Response to consultee comments in blue:

West Sussex Landscape	
Require the following information and modifications: (1) South of the Main Avenue should have a continuous verge (better for tree establishment / long term survival than individual planting locations). Buildings need to be set back from the footway edge to give good separation between the building elevation from trees. Continuous verge also removes the need for granite sett edging and tree grills which will require maintenance and may become distorted. (2) For any remaining tree pits section / plan drawings are required. Stakes / ties are also indicated instead of ground anchors which is unusual. (3) Services to be located in footway / carriageway not verges. (4) Error on the outline specification on LA101: subsoil British Standard is BS8601:2013. (5) Reconsider use of hornbeam, with other suitable species.	(1) The majority of south of the Main Avenue abuts the retail element that will be delivered as part of a separate RMA. It is considered that a continuous verge would not be appropriate as this area will form part of the public realm that will be developed as part of the retail RMA. As detailed in the Development Fr

Tree Planting Details LA108

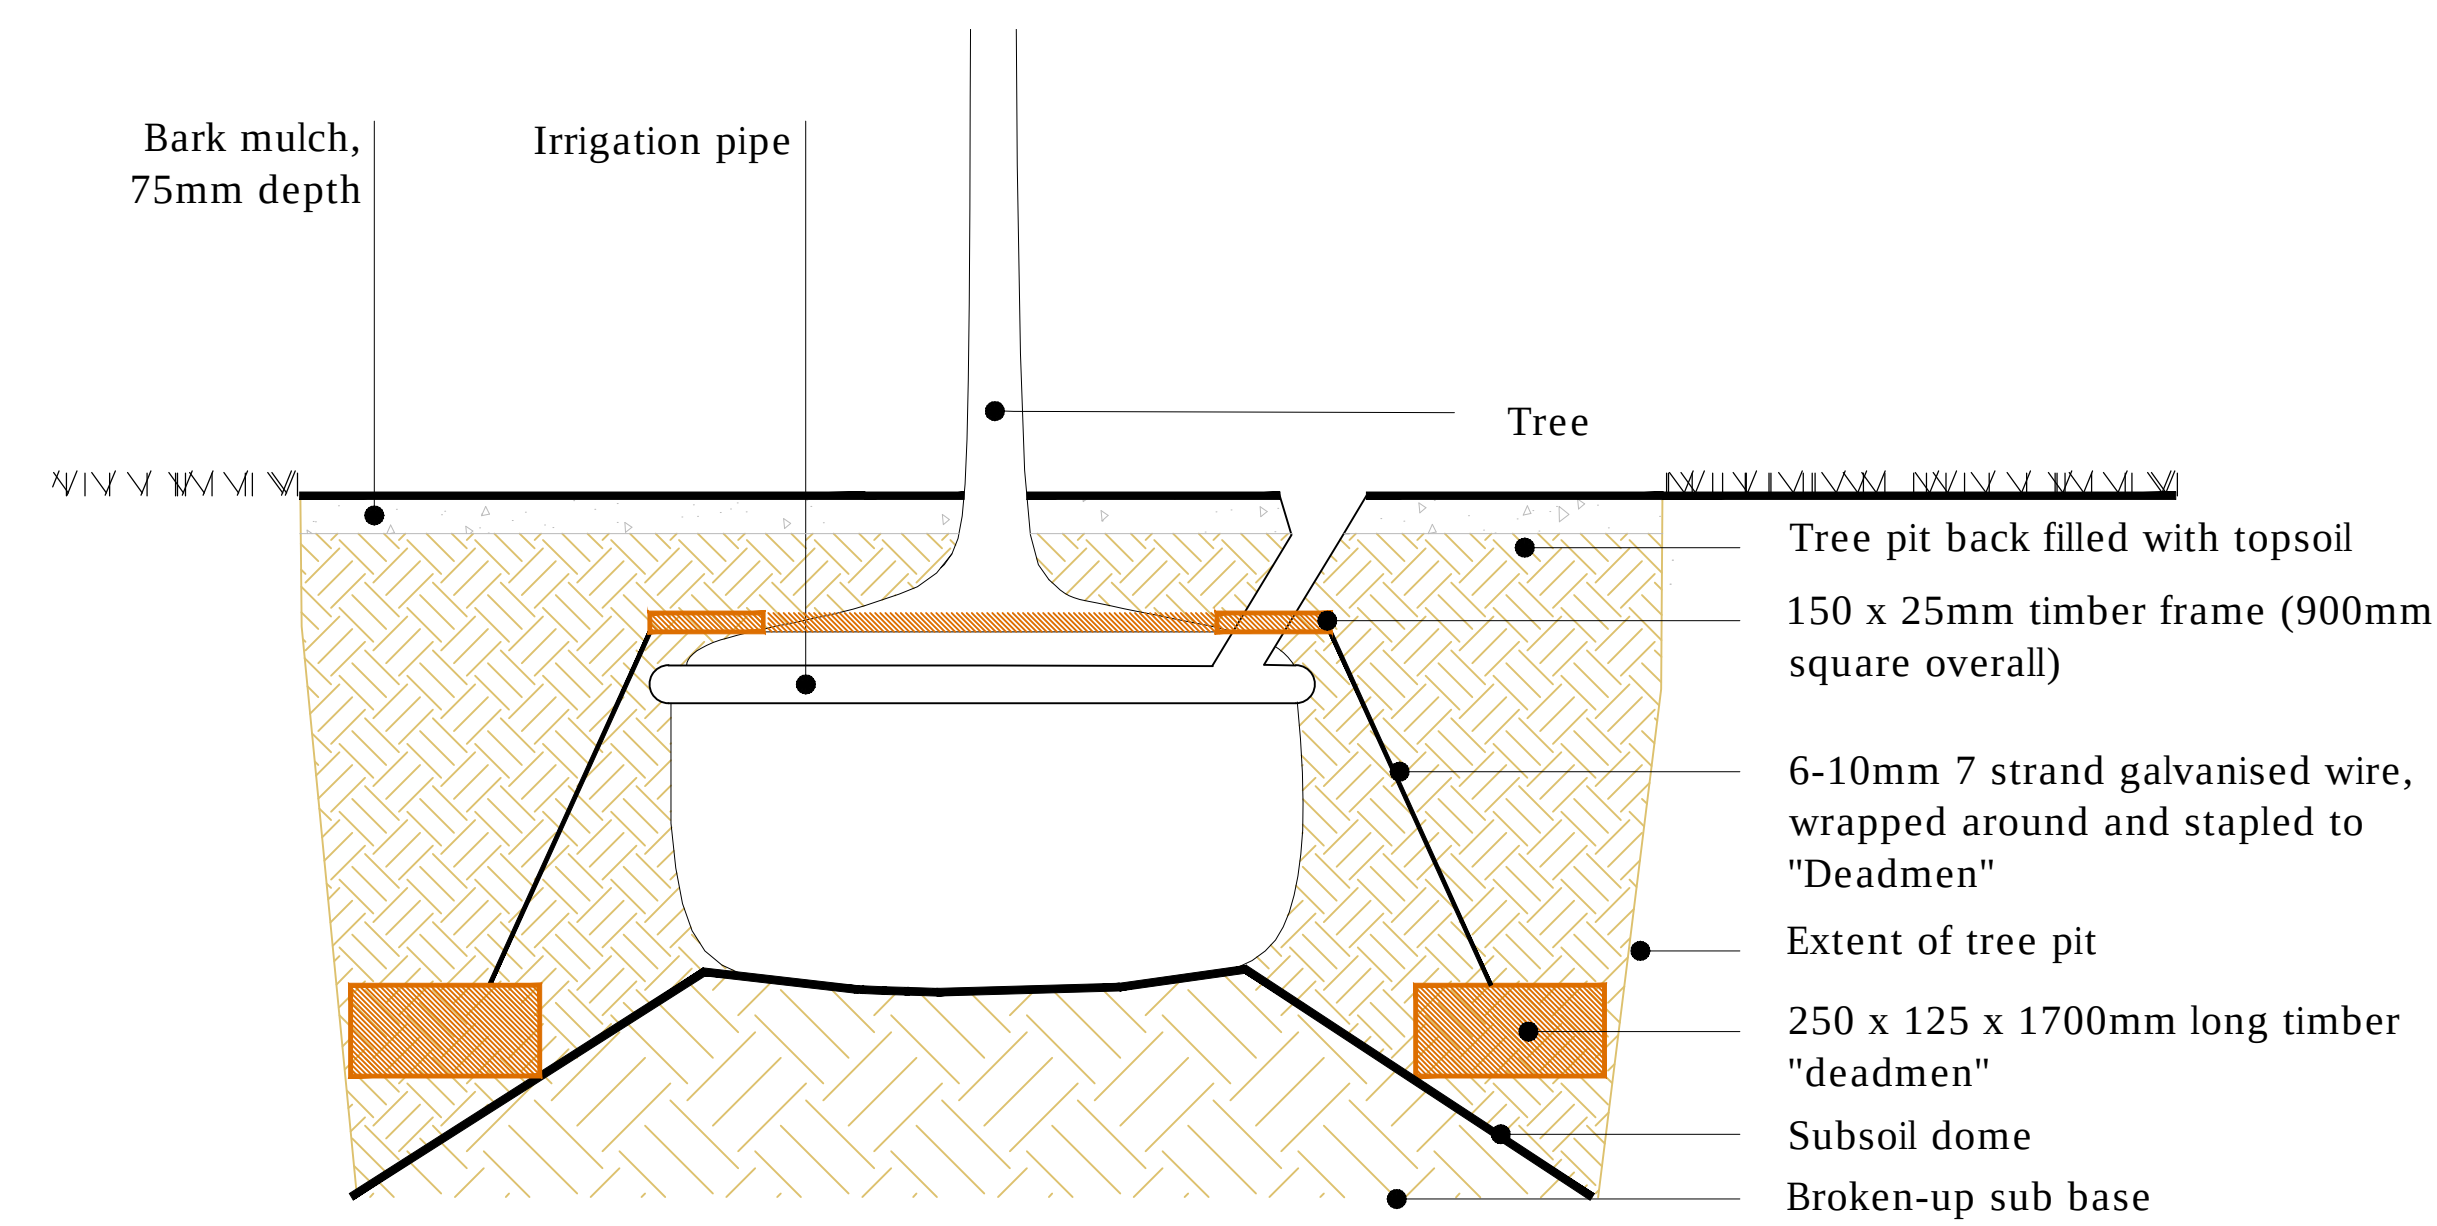
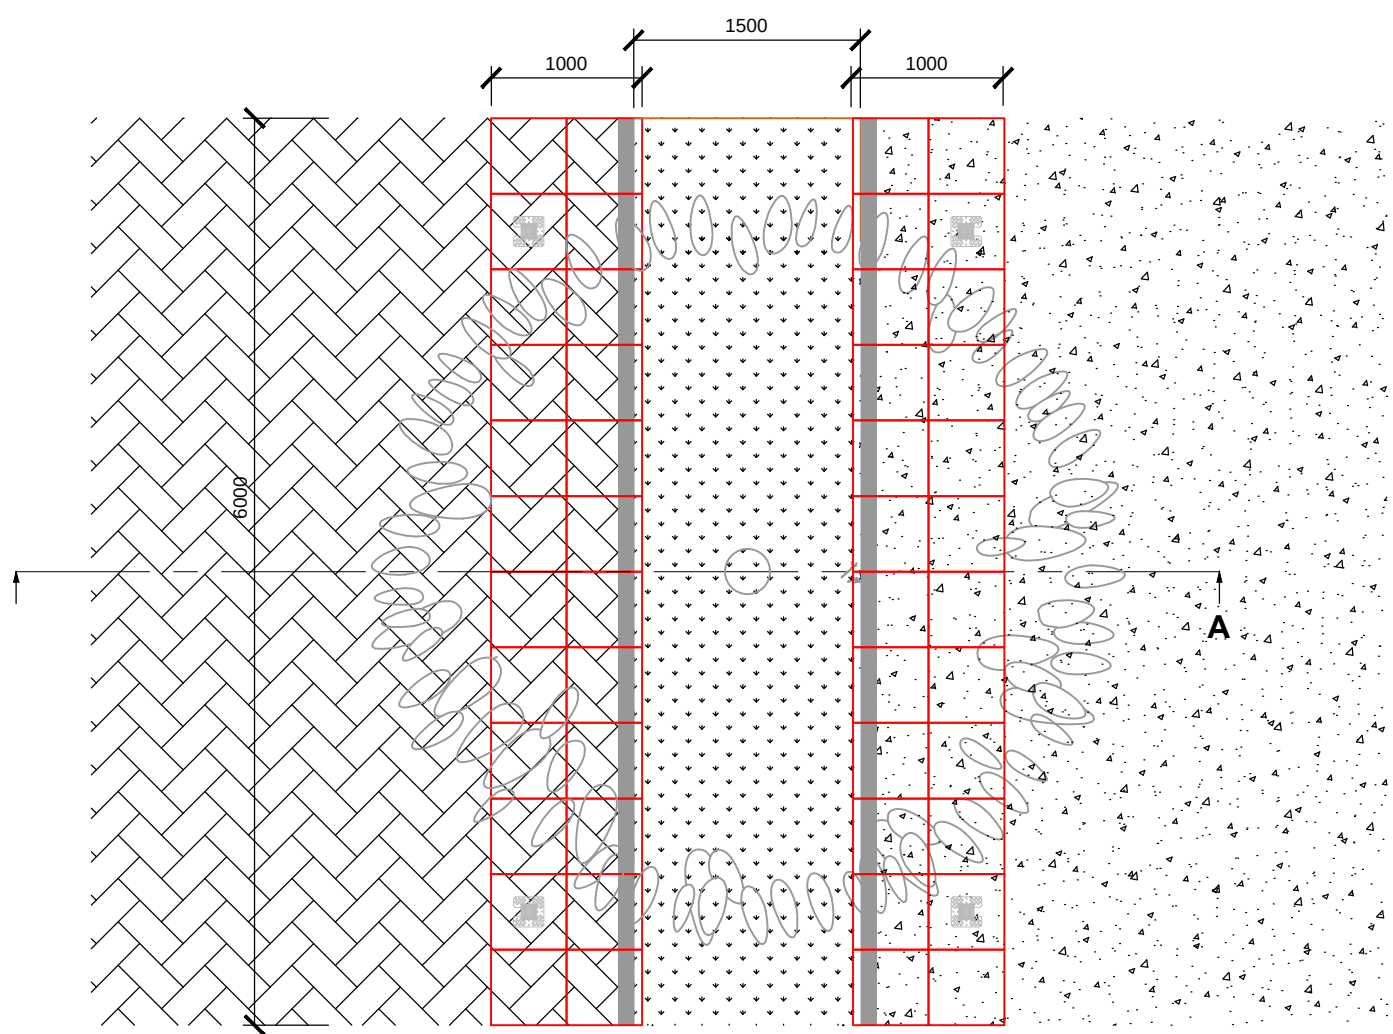
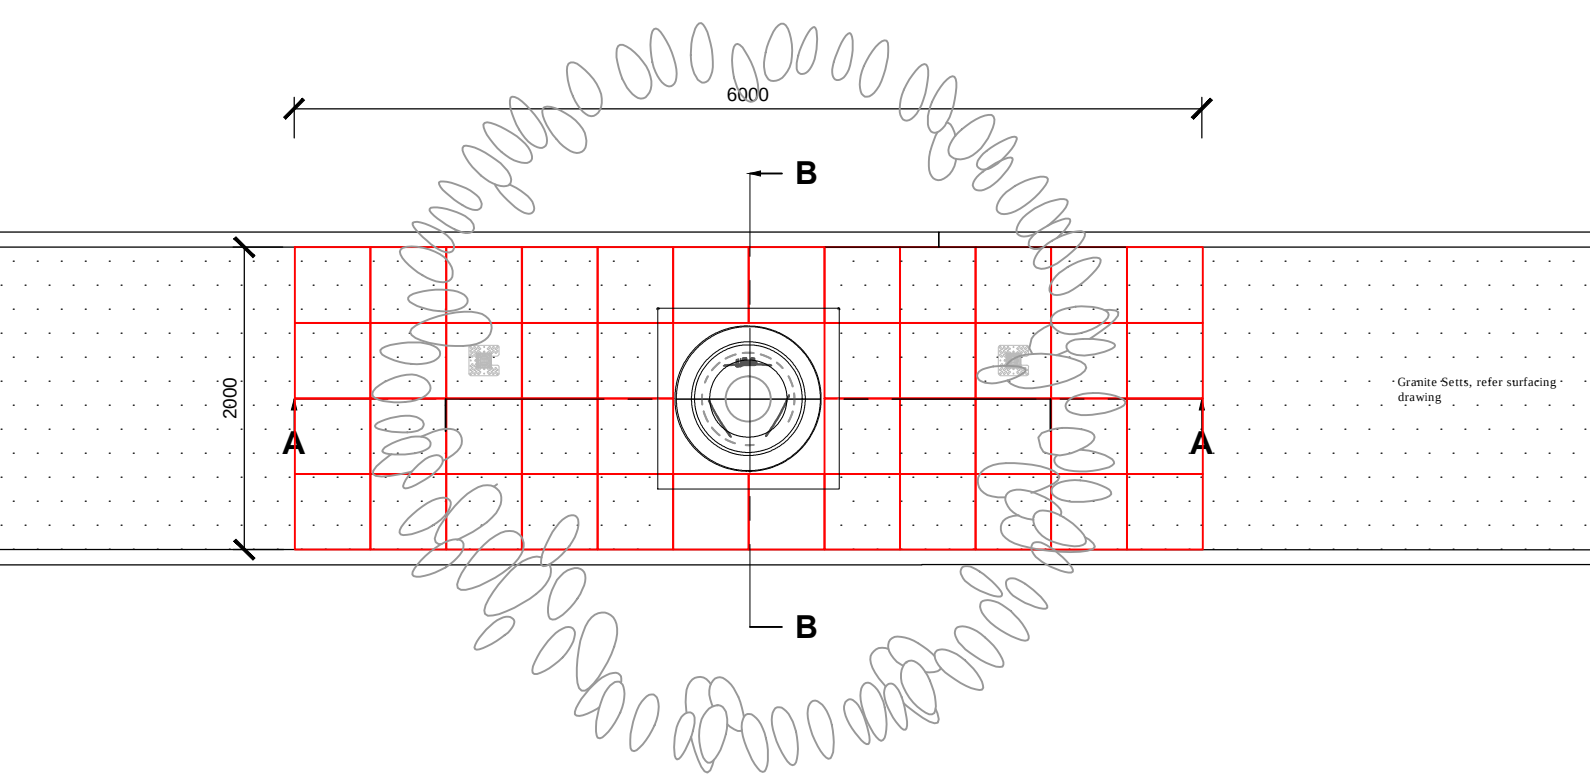
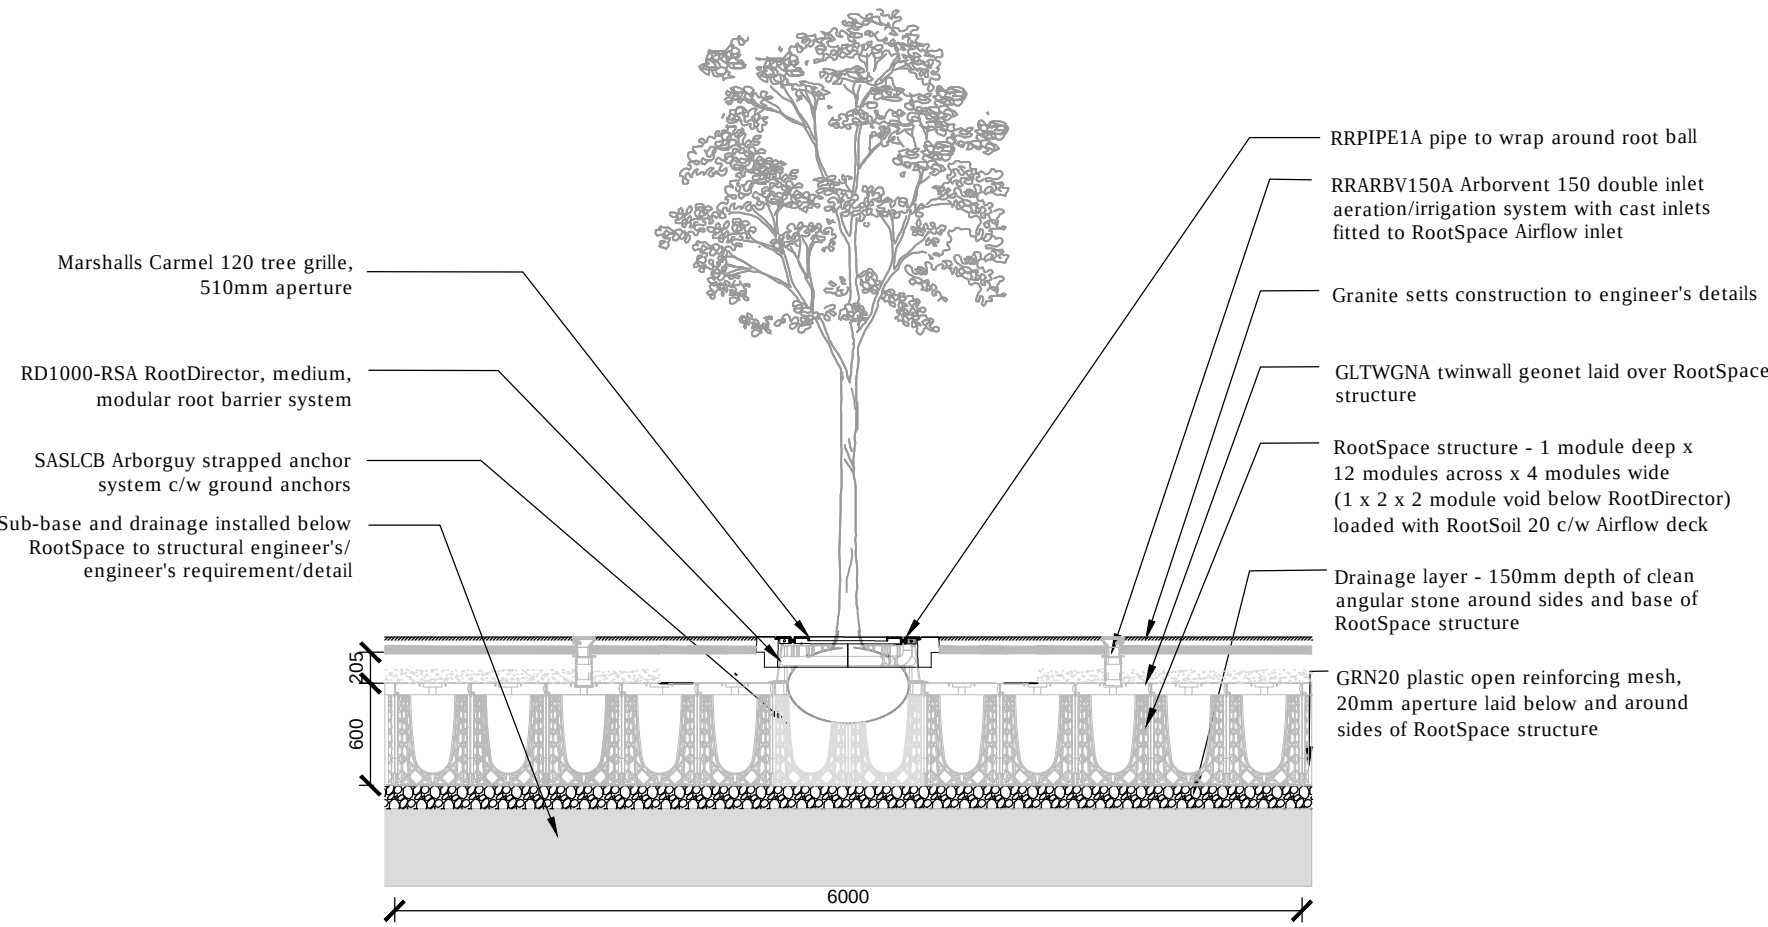
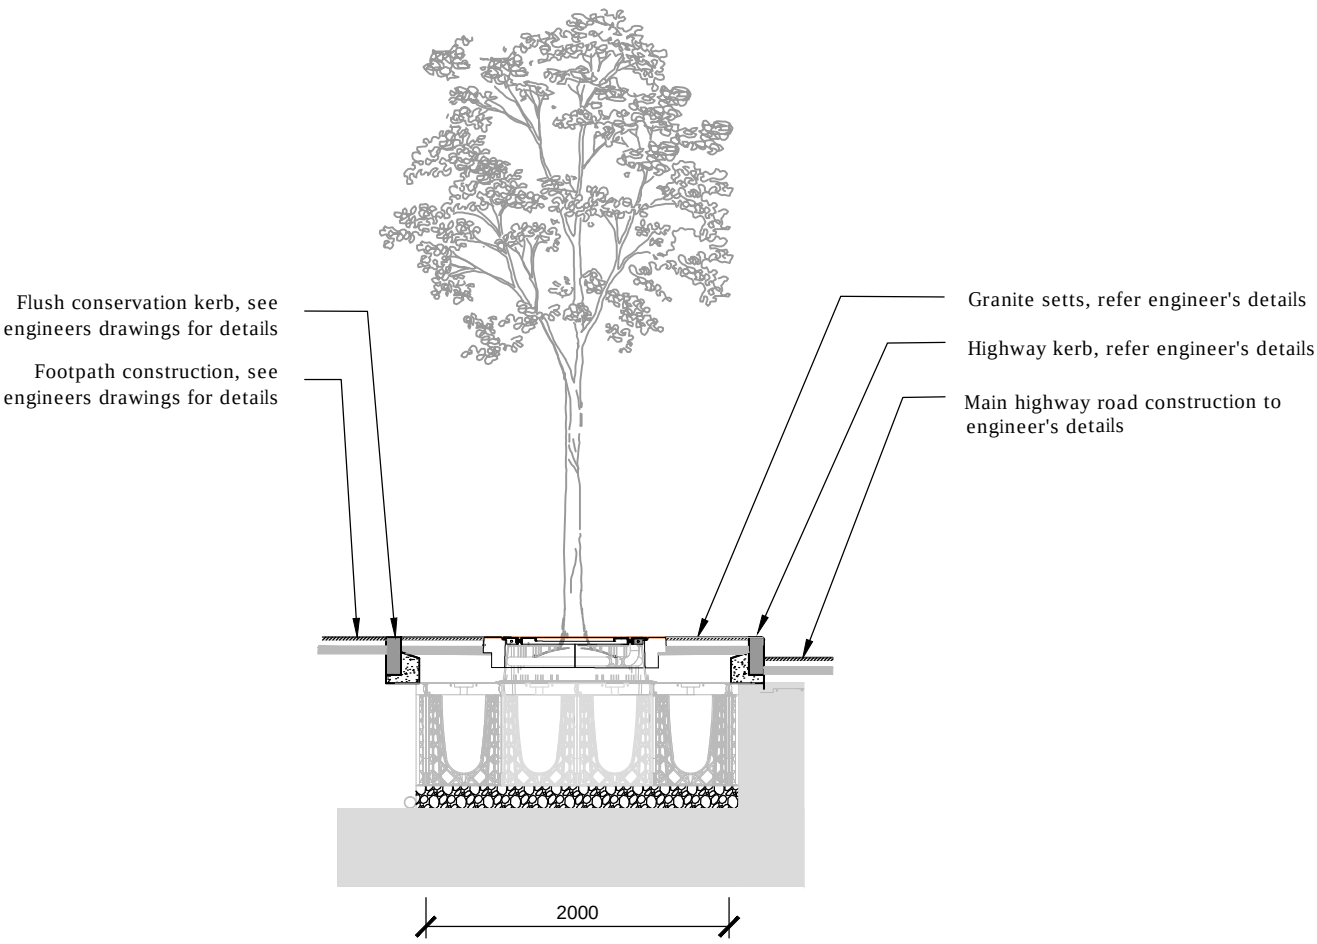
(1) Also require a review of tree species choice and form in accordance with West Sussex Landscape. Frax Frax would be a welcome species choice in this area. (2) Planting pit formation cross section and specification required. (3) Confirmation of who will be responsible for maintenance. (4) Clarification if LEAP is to be fenced / gated area or play	(1) Noted. (2) Noted refer to drawing LA108. (3) The management company that has been established for the site. (4) Noted– suggest fenced. Landscape drawings have been amended accordingly.
West Sussex Highways	
Require the following information and modifications: (1) An RSA and Designers Response is required. (2) Tracking diagrams of Main Avenue (bends and / or curves) required (3) Tracking of refuse and fire vehicles to Plots 95-100 and 117-122 shows overriding of access points to the main carriageway and over-sailing of the footway opposite. Or else consider bin stores located within suitable distance to the main access roads. (4) The raised table adjacent to plot 95-100 should be reviewed as the surface treatment is not consistent with the other tables elsewhere. (5) Layout differences with s73 Master Plan need explaining.	(1) A Stage 1 RSA and associated Designer's Response Report was provided with the original submission. This has been updated to account for the amended layout. (2) The anticipated vehicle swept paths of a large refuse vehicle and large car are indicated on drawings numbered A/PHLITTLE-INT.1/TK-1 and 2. (3) Plots 95-100 – A bin collection area is located just inside the parking area which would allow the refuse vehicle to wait on Road Three to collect bins thus avoiding the need to turn within the car parking area. Plots 117-122 – A bin collection area has been added adjacent to Road Two allowing the refuse vehicle to wait on Road Two and thus removing the requirement for the refuse vehicle to turn within the parking area. (4) Bitumen surfaced raised tables are proposed on the Main Avenue because the Main Avenue is to become a bus route and Bitumen is considered a more durable surface material for such locations. (5) The layout has been reviewed to accommodate all comments raised. The parameter plans submitted with the s73 application form the base of the detailed development proposed through this RMA
